From: planning
Subject: FW: Ribble Valley ref 3-2016-0577 Ribblesdale View Chatburn 4 dwellings
Attachments: ribblesdale view NR land.pdf

FAO ADAM BIRKETT
3/2016/0577
LAND OFF RIBBLESDALE VIEW, CHATBURN, CLITHEROE
DEMOLITION OF 14 GARAGES AND ERECTION OF 4 DWELLINGS
MRS HARRISON
377025 / 444190

S.J. Bialecki Limited Building Surveyors
Drawing no 5005
Scale 1:100
Proposed Site Layout
Proposed Residential Development On Land At Ribblesdale View Chatburn

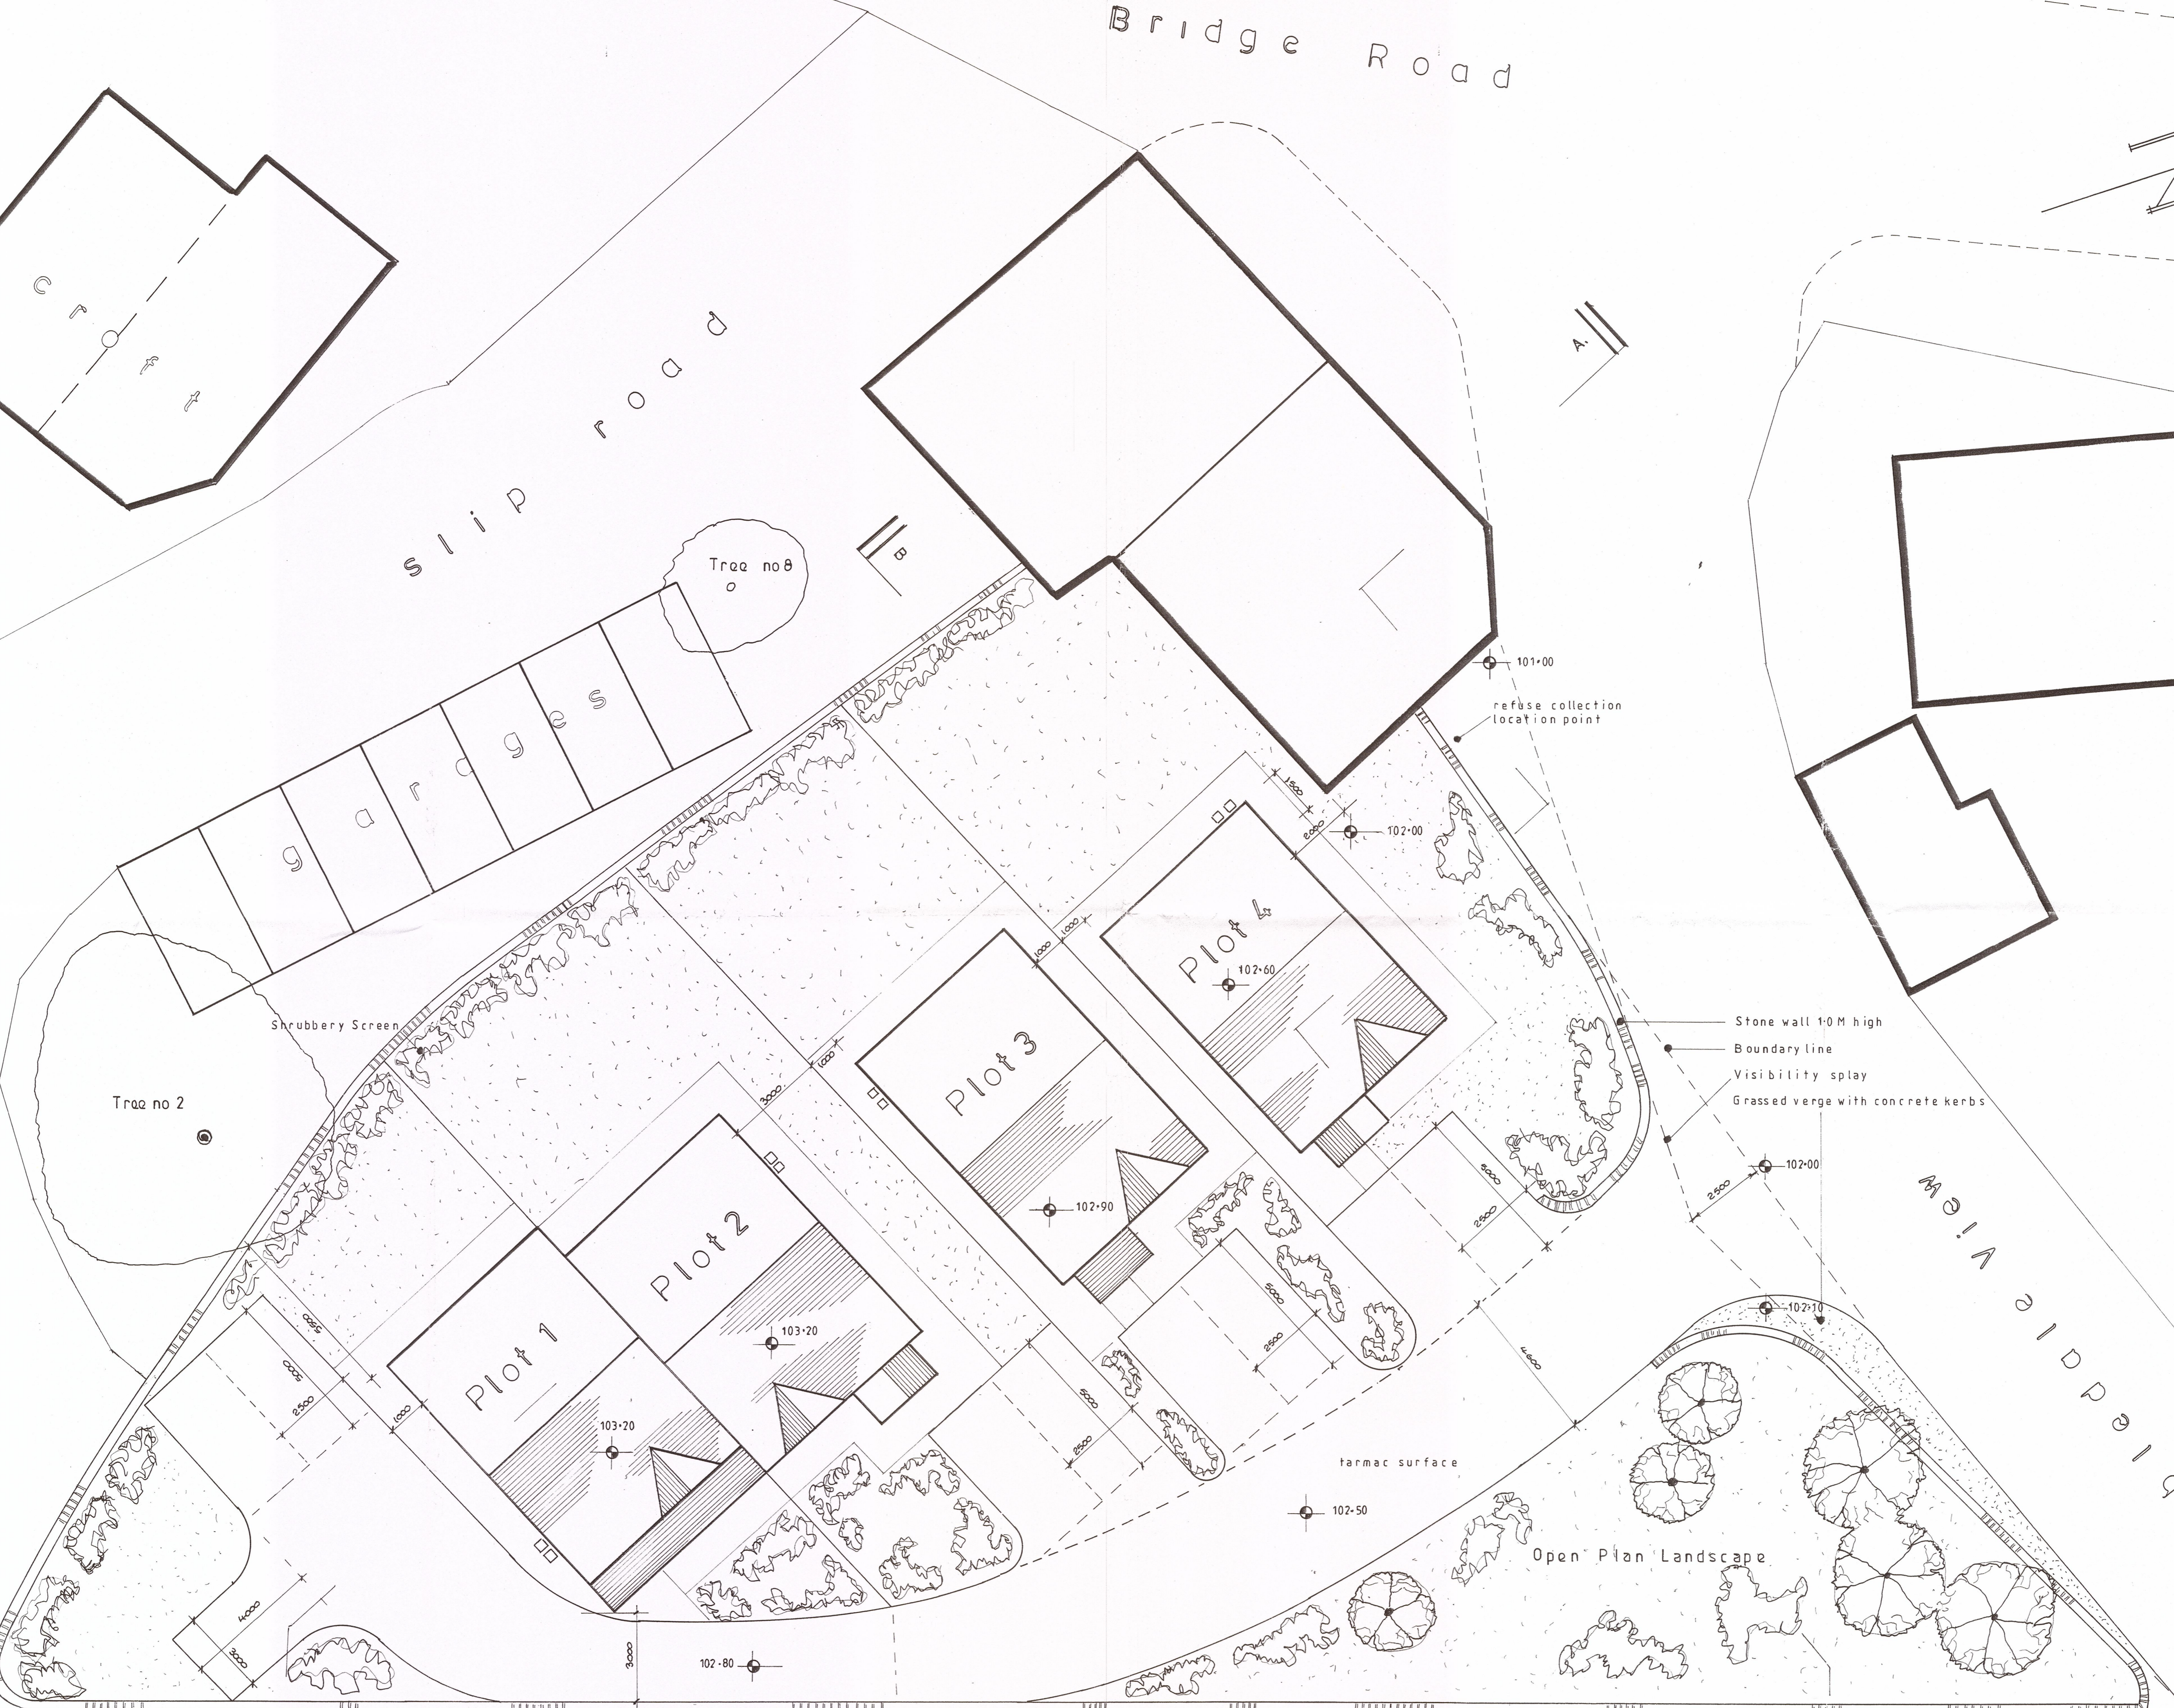
The developer states that the east boundary is separated from the cutting by a 5m width of land the full length of the site. The land in question is owned by Network Rail (see attached plan, railway land shaded in green). When designing proposals, the developer and LPA are advised, that any measurements must be taken from the operational railway / Network Rail boundary and not from the railway tracks themselves. From any existing railway tracks themselves to the Network Rail boundary fence, will include critical infrastructure (e.g. cables, signals, overhead lines, communication equipment etc) and boundary treatments which might be adversely impacted by third party proposals unless the necessary asset protection measures are undertaken. No proposal should increase Network Rail's liability.

The developer appears to be proposing a 1m high stone wall adjacent to the railway boundary behind which will be an open space and an access road.

Network Rail will need to review and agree all excavation and earthworks within 10m of the railway boundary to determine if the works might impact upon the support zone of our land and infrastructure as well as determining

relative levels in relation to the railway. Network Rail would need to be informed of any alterations to ground levels, de-watering or ground stabilisation and we would need to agree the works on site to ensure that there is no impact upon critical railway infrastructure.

Any works adjacent to the boundary could impact upon the support zone of the cutting and any buried services along the boundary.

Network Rail would request that instead of a 1m stone wall the developer provides suitable 1.8m high trespass proof fencing adjacent to the boundary with Network Rail land including the open space area. This is to prevent any unauthorised access to railway land by anyone using the site or the open space including minors. All boundary treatments must be constructed wholly within the applicant's land ownership footprint including foundations and Network Rail existing boundary treatment must not be removed or altered in any way.
